**PREFERRED PROJECT REPORT
MAJOR PROJECT APPLICATION NO. 06_0237**

REDEVELOPMENT OF TWIN TOWNS SERVICES CLUB

**AT LOT 1 DP 777183
WHARF STREET TWEED HEADS**

PREFERRED PROJECT REPORT

Fire Stair detail with feature fine vertical aluminium screening. Internal lighting to the fire stair is intended to create a lantern effect to the stair at night.

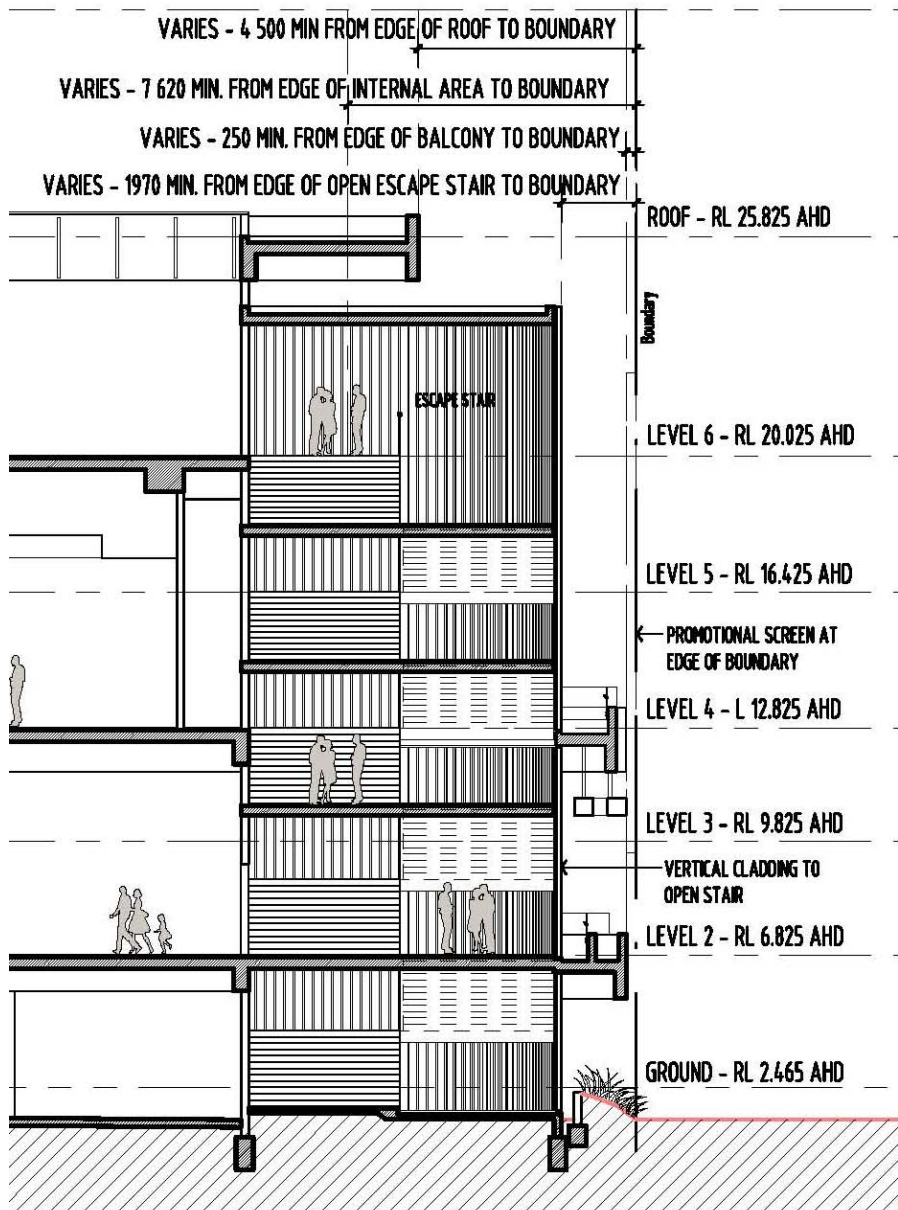
"The location of the new fire stairs creates a blind spot and makes the pedestrian route potentially very dangerous for public trying to negotiate it."

In addition, the design has addressed comments regarding aesthetics and revised the fire stair to be more transparent by incorporating vertical aluminium screening elements.

PROJECT No.: JOB # 335
DATE: 31.10.08
DA1-10.42 REV. A

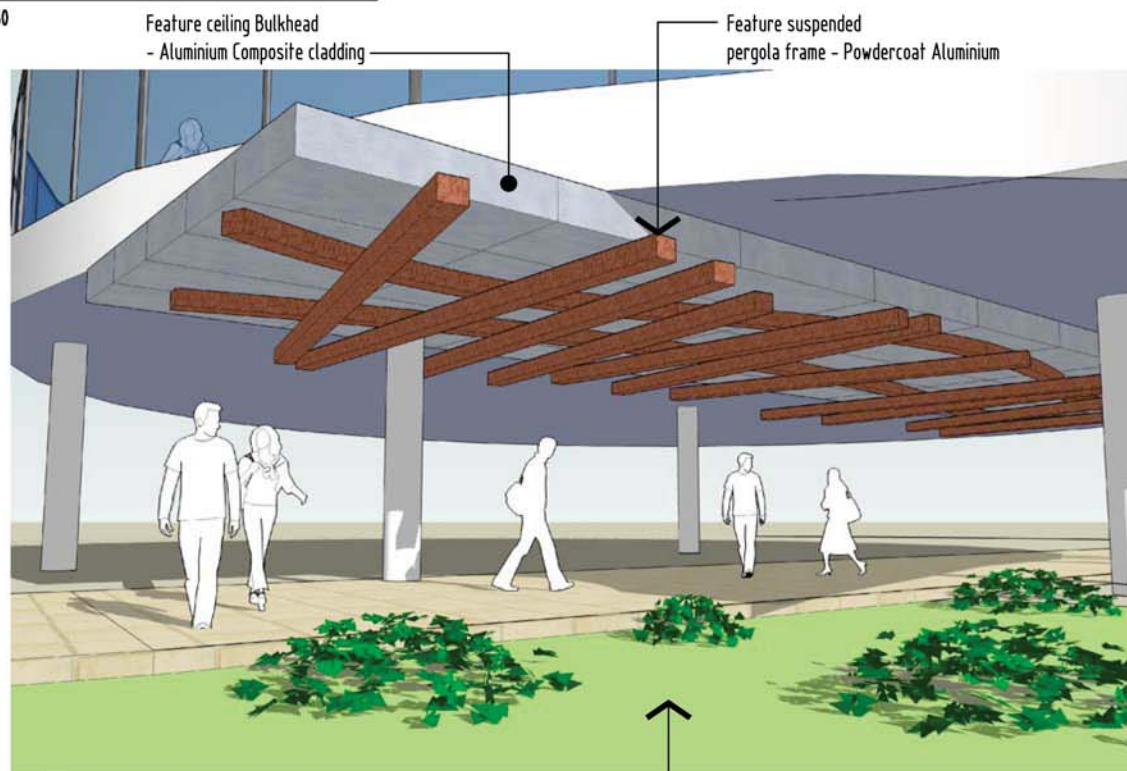
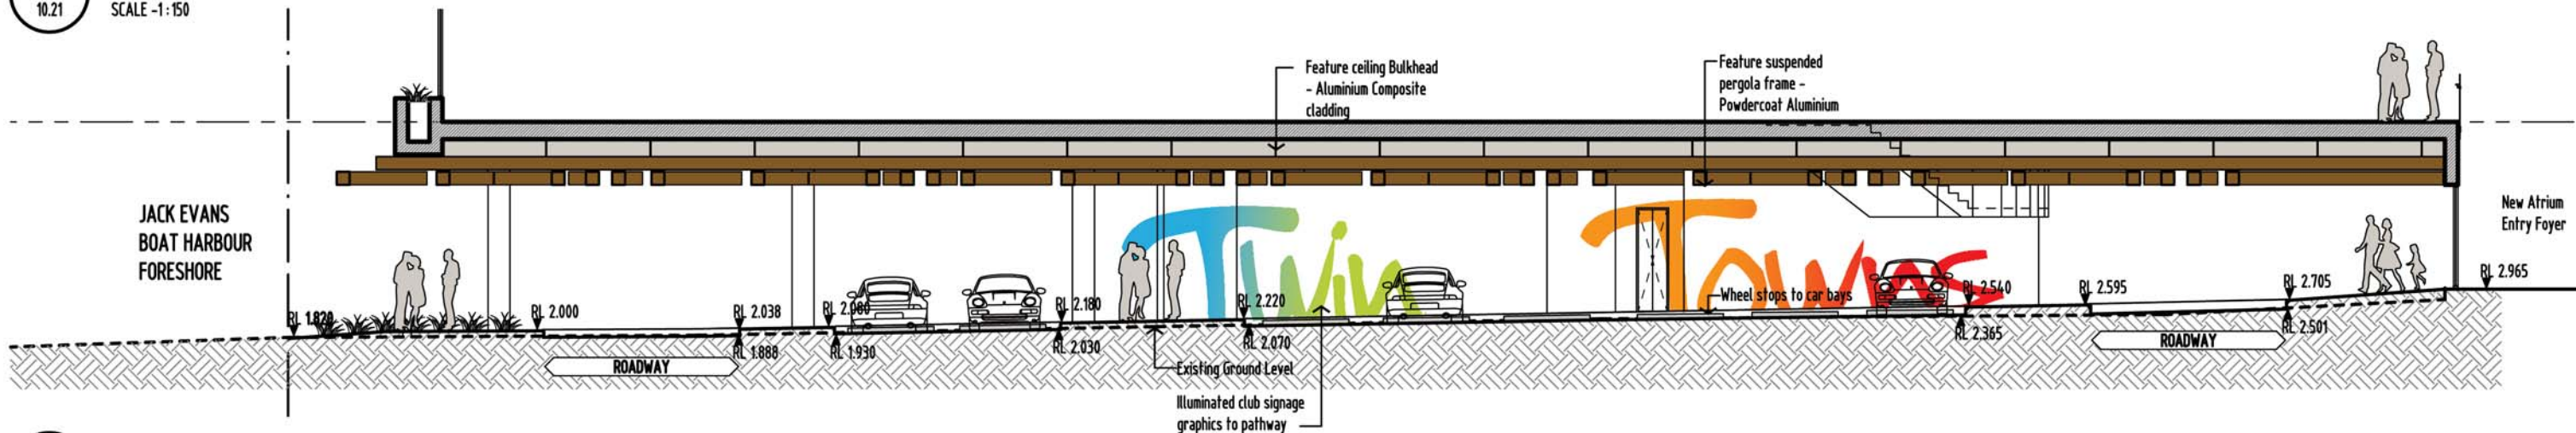
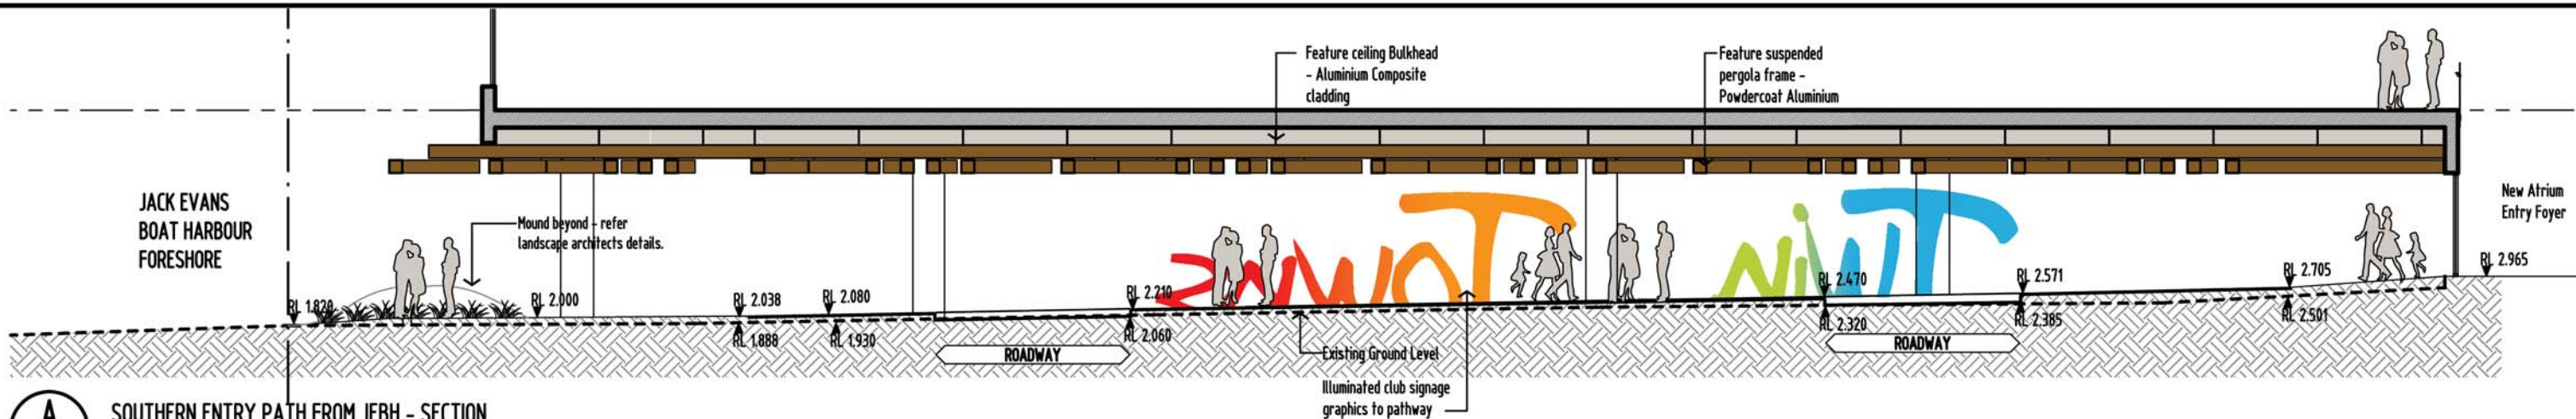
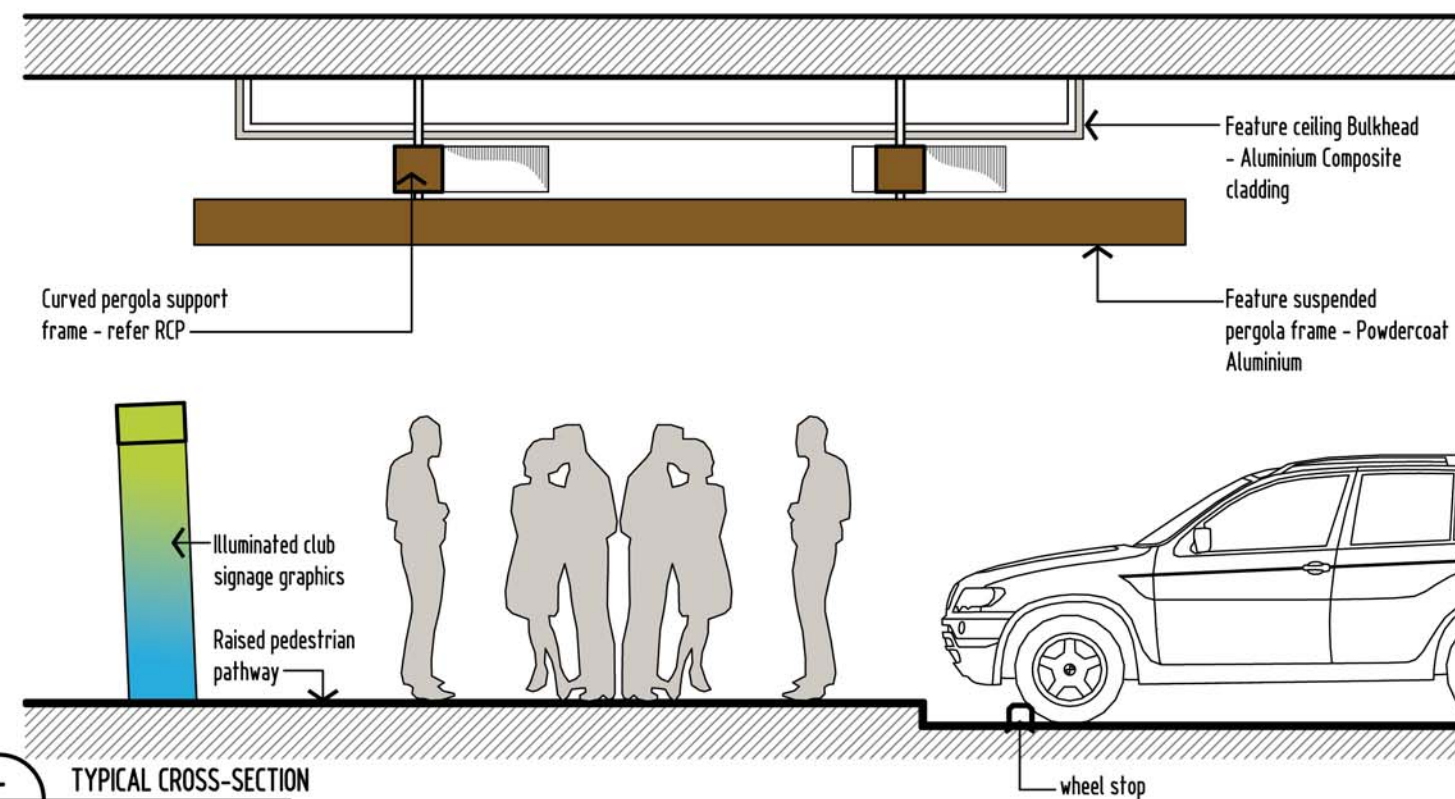
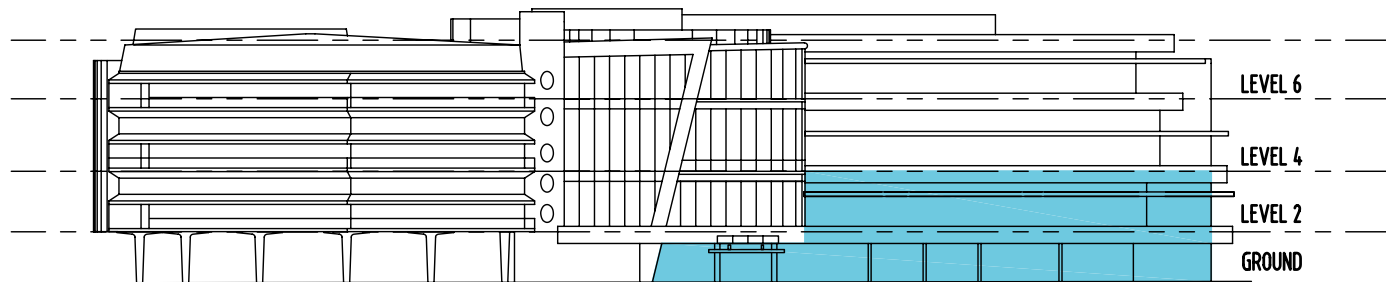
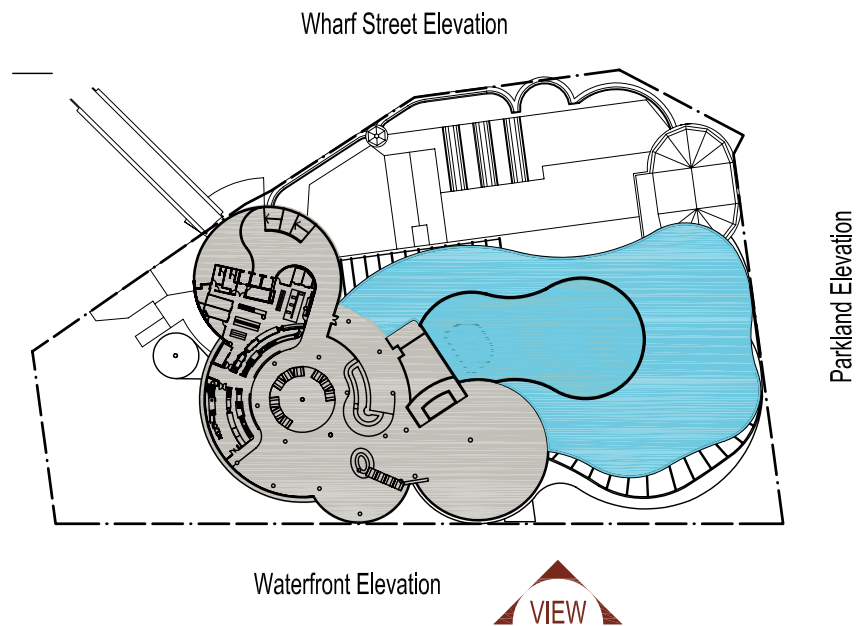
"The overly curved vehicular driveway at the entry to the Club diminishes the access for pedestrians."

The Application Plans have been amended to provide two separate pedestrian pathways from Jack Evans Boat Harbour to the Club entry (see Plan DA1-10.42 Revision A, DA1-10.24 Revision A and DA1-10.21 Revision C).

A new fire stair to the Millenium core has also been provided with undercroft which improves and addresses pedestrian visibility.
